CITY OF ALBUQUERQUE

RE: **9808 Davenport NW**
Request for Pad Certification – Not Accepted
Engineer's Stamp Date 7/17/18
Certification Dated: 8/8/18
Hydrology File: B13D011A

Based on the submittal received on 8/16/18 the above-referenced Certification is not approved for Building Permit. Please address the following:

DATE	REVISION	LOT 3, BLOCK 24, PARADISE HILLS ALBUQUERQUE, BERNALILLO COUNTY, NM
7/17/18	ADK, OJA, HPBOL, SANDRICKS, DTC	9808 DAVENPORT, NW Grading & Drainage Plan
DESIGNED BY: PWC	DRAWN BY: COE	TERRANOVA BUILDERS
CHECKED BY: PWC	DATE: 6/23/18	FILE #: G/D
		1 OF 1

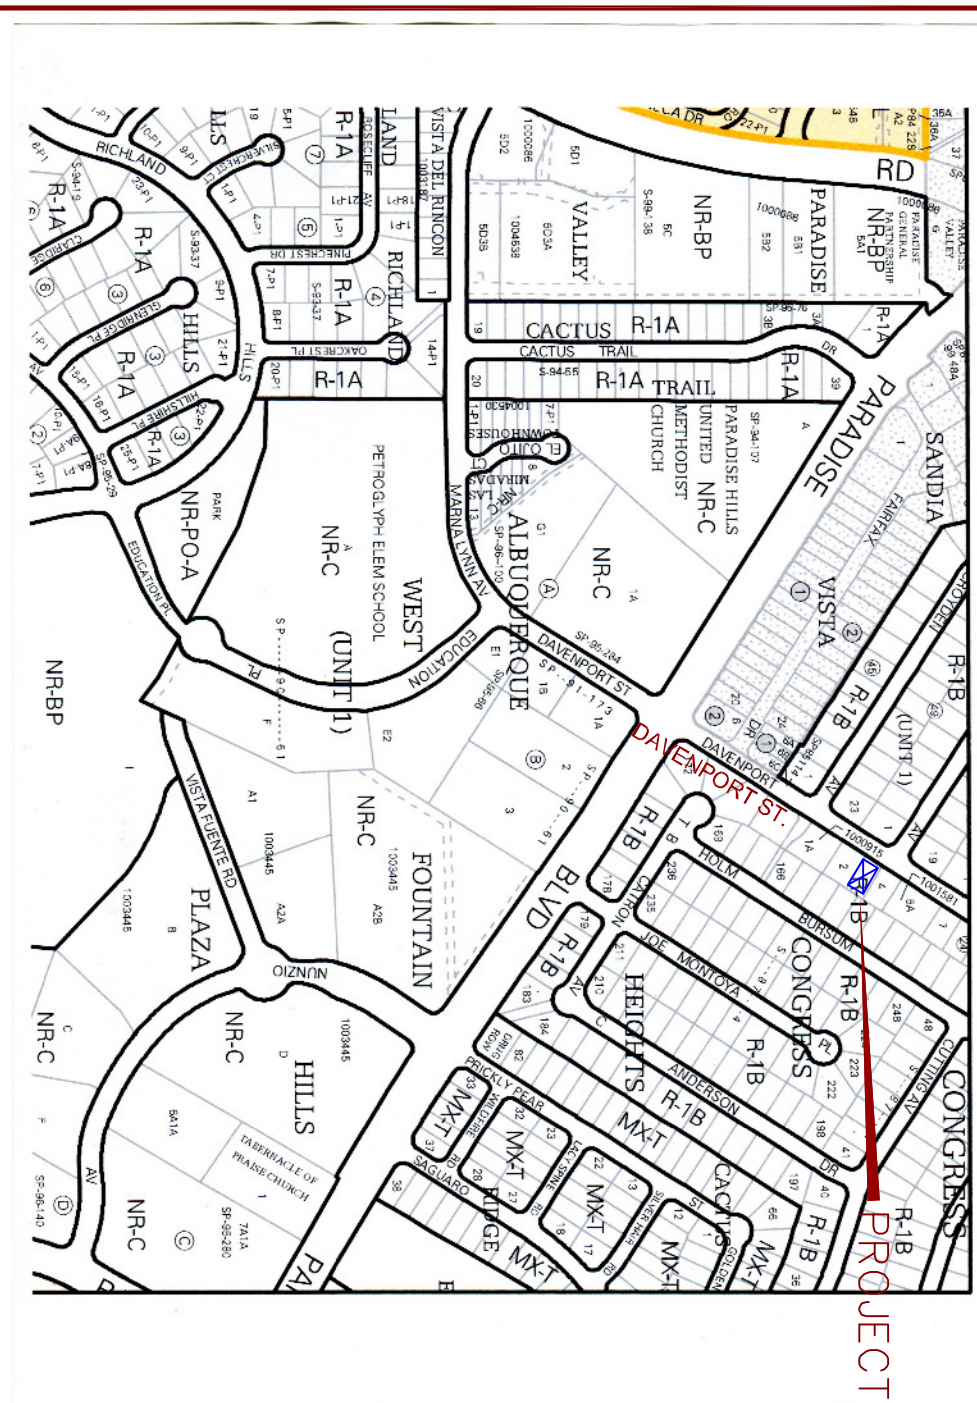
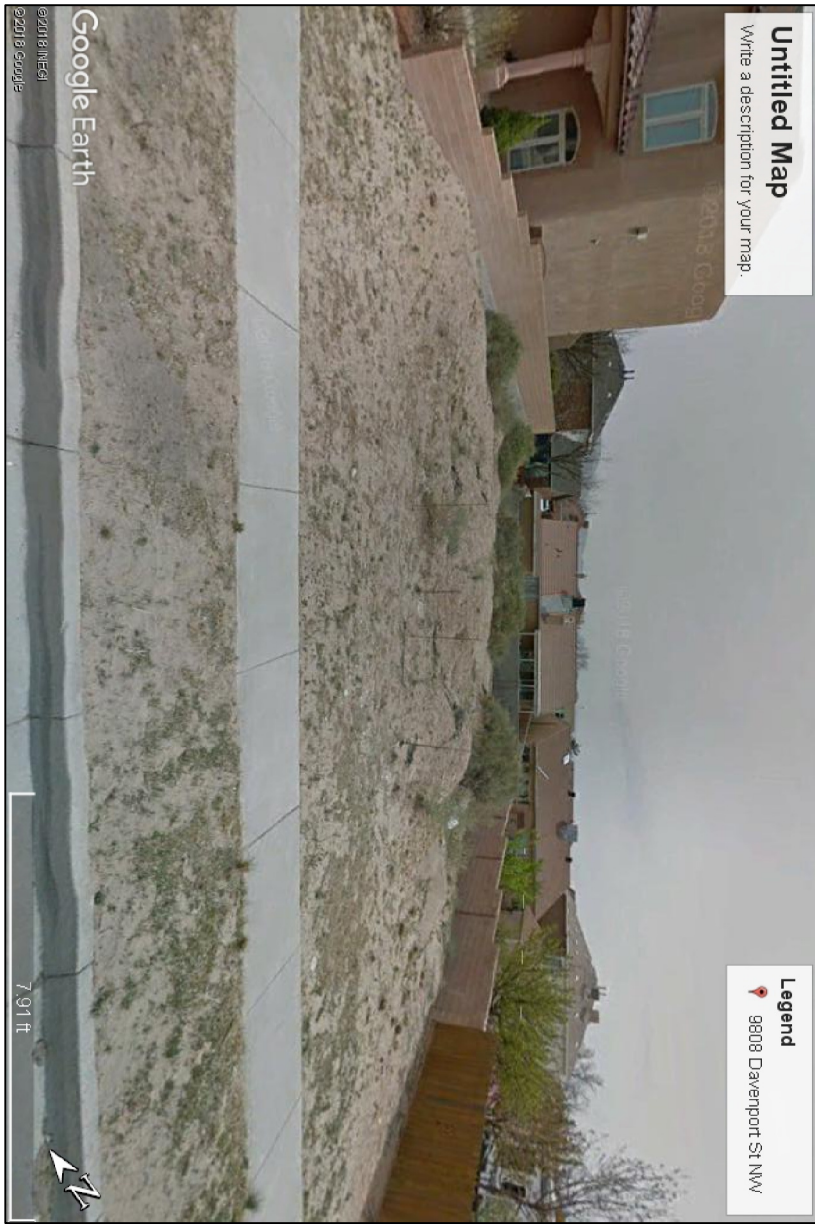
1. Remove dirt from neighboring wall on the south side.
2. Prepare the subgrade for the stemwall
